# Memorandum

**To:** Glenn Harmon  
**From:** Mike Nugent/Manager of Inspection Services  
**Date:** 08/19/2003  
**Re:** 20-24 Brackett St. (058 F013)

TITLE SHEET &
CODE RESEARCH

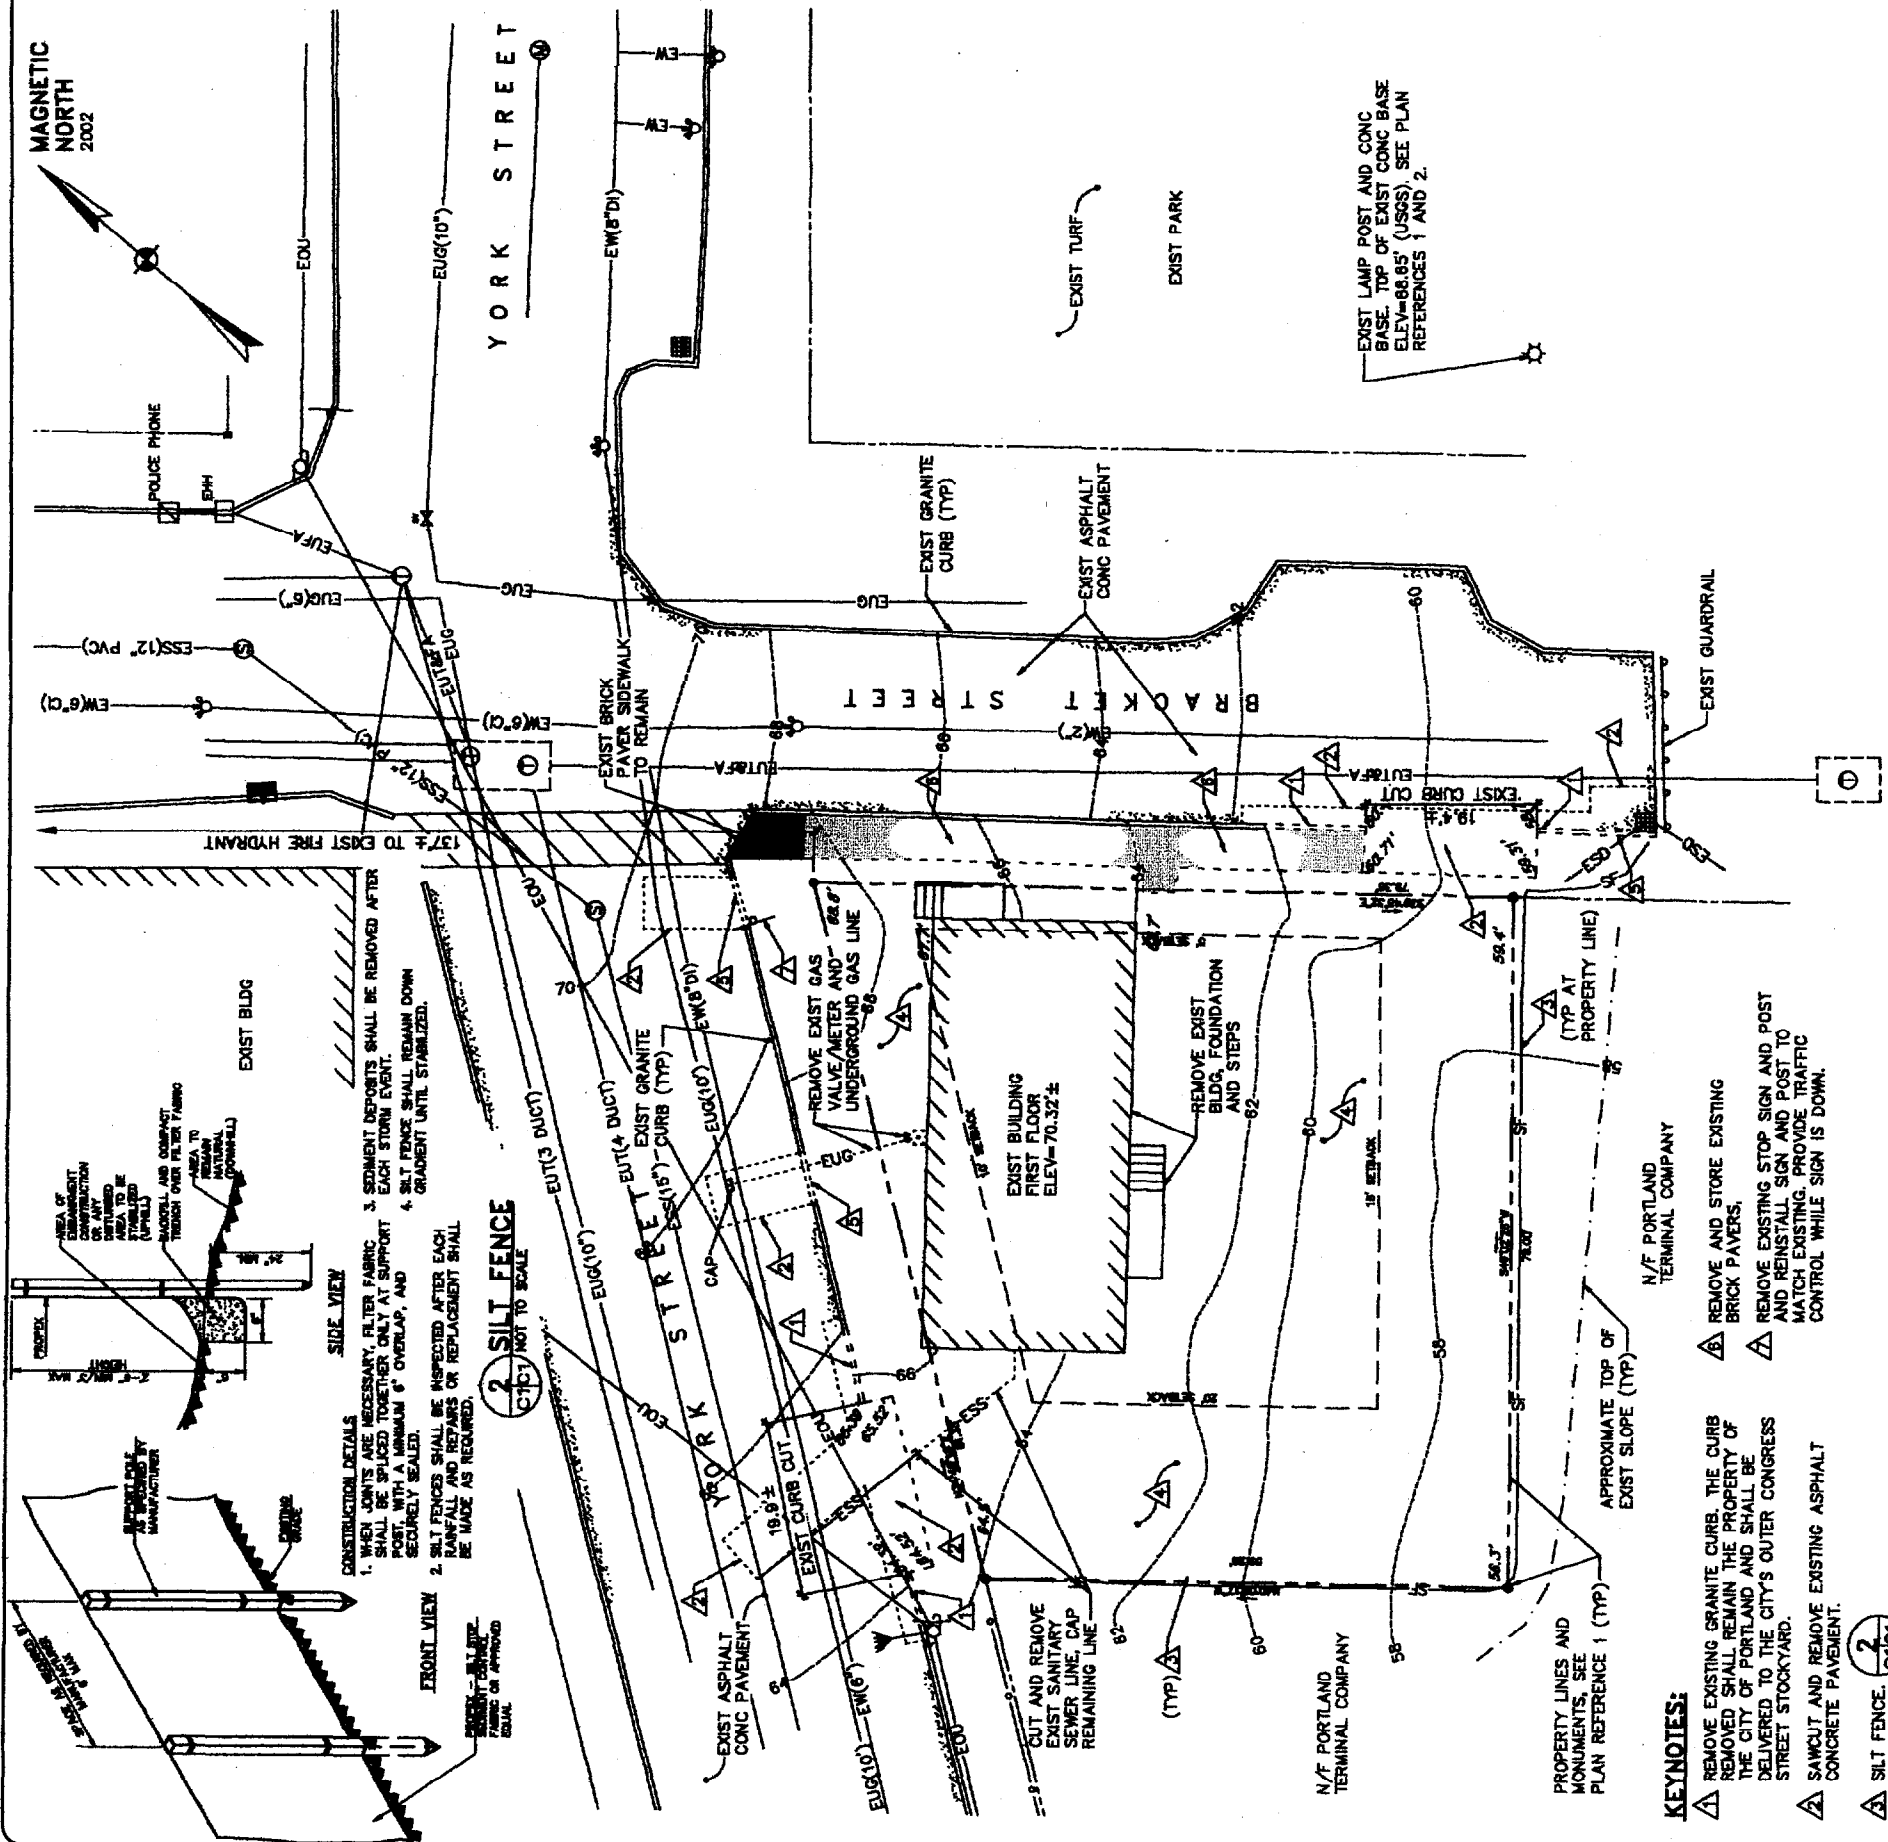
- 1) We will be receiving new construction documents upgrading the type of construction to 2A for review. In those plans, please provide documents that reflect the documentation required in items 3,4,5 & 6.
- 2) I have attached a Sample of an acceptable Special Inspections format. Please review and re submit.
- 3) Please include the design load of the balconies in the new submissions. Also provide a statement in the stamped roof assembly structurals that will insure design in accordance with section 7.3 of ASCE 7.
- 4) Is the sprinkler system and NFPA 13 or 13 R system?
- 5) We will need a separate set of stamped mechanical drawings, w/ permit prior to installation.
- 6) Please provide a cross section of the roof assembly floor-ceiling assemblies w/ UL certifications of fire resistance and sound transmission ratings.
- 7) Planning has not authorized permit issuance as of Monday 8/18/03.
